**WEST SUSSEX COUNTY COUNCIL
STRATEGIC PLANNING CONSULTATION**

DATE: 29th July 2015

SUBJECT: F/7/15/PL - Application for outline planning permission with some matters reserved for 45 x new dwellings and new access. This application also lies within the parish of Yapton.

LOCATION: Land south of Burndell Road, Ford, West Sussex, BN18 0HR

Proposed access and highway improvements plan (Stiwell Partnership)

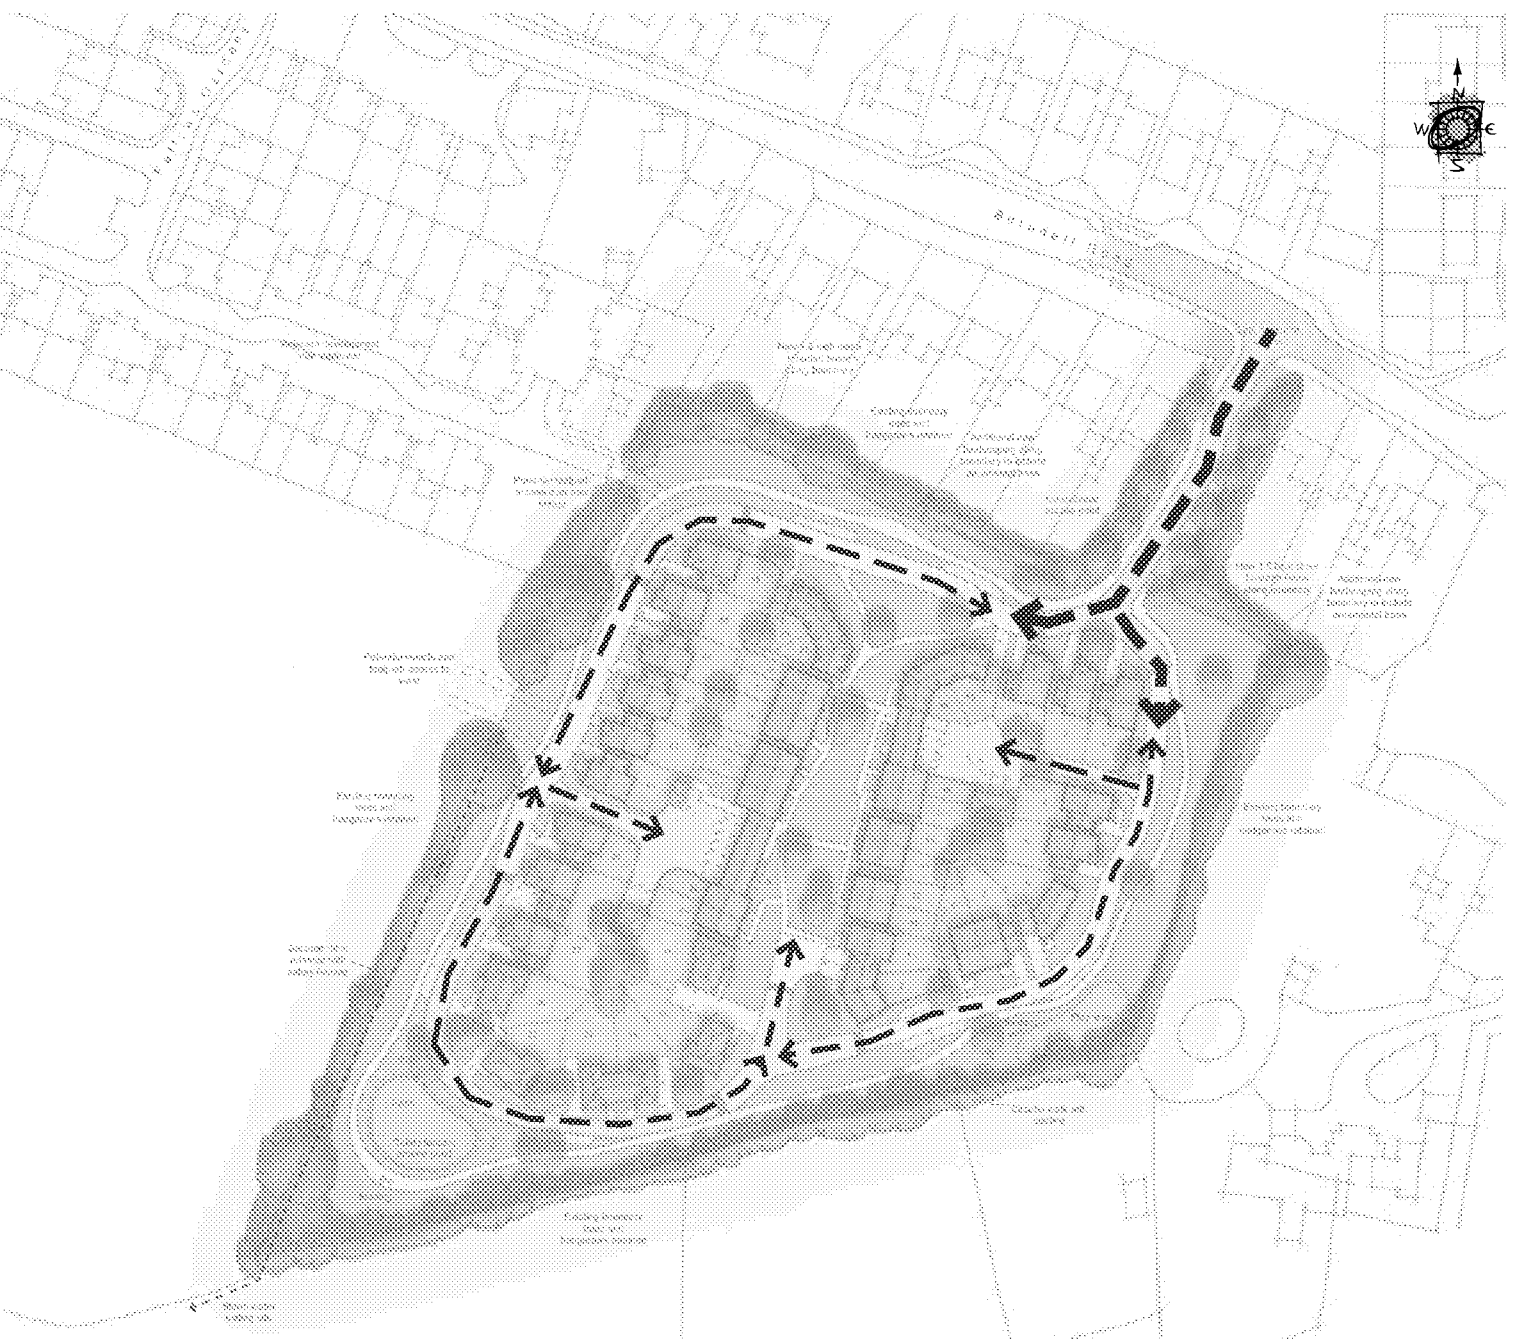
Drawing No. TSP/BRO/P2551/02 shows an uncontrolled pedestrian crossing with tactile paving across Burndell Road immediately adjacent to a re-sited bus stop. A blind or partially sighted pedestrian crossing Burndell Road south to north will have their route across the road blocked by a bus standing at the bus stop which could lead to vehicle/pedestrian collisions.

It is recommended that the proposed location for the bus stop is re-considered.

It is proposed that there will be new 2.0m wide footways on both sides of the access road where it meets Burndell Road with tactile paving to assist blind and partially sighted pedestrians to cross the new access road. The audit team are concerned that the section of new footway on the east side of the access road is very short and does not lead to a continuous footway on the south side of Burndell Road. Blind and partially sighted pedestrians may become confused by the lack of footway and may lead to such pedestrians attempting to cross Burndell Road which could result in vehicle/pedestrian collisions.

It is recommended that the short section of footway is deleted from the proposals.

The application shows both bus stops re-located in order to make provision for pedestrians crossing Burndell Road. Shelters with real-time passenger information and seating should be provided at the bus stops. This to be secured in a S106 Agreement. The final location and design of any shelters should not compromise highway safety at any of the nearby access points nor footway.

In order to remove the possible vehicle/pedestrian conflict, drawing TSP/BRO/P2551/02H now shows a re-located uncontrolled crossing approximately 24m to the west. This would allow pedestrians to cross away from the bus stops and waiting buses.

Footway now removed from proposals as shown on drawing TSP/BRO/P2251/02C.

1. **Access** – No development shall be commenced (including works of demolition) until the access, footway provision, pedestrian crossing and any other associated highway works, as generally shown on drawing TSP/BRO/P2551/02 H, has been provided to the satisfaction of the Local planning Authority after consultation with the Highway Authority.
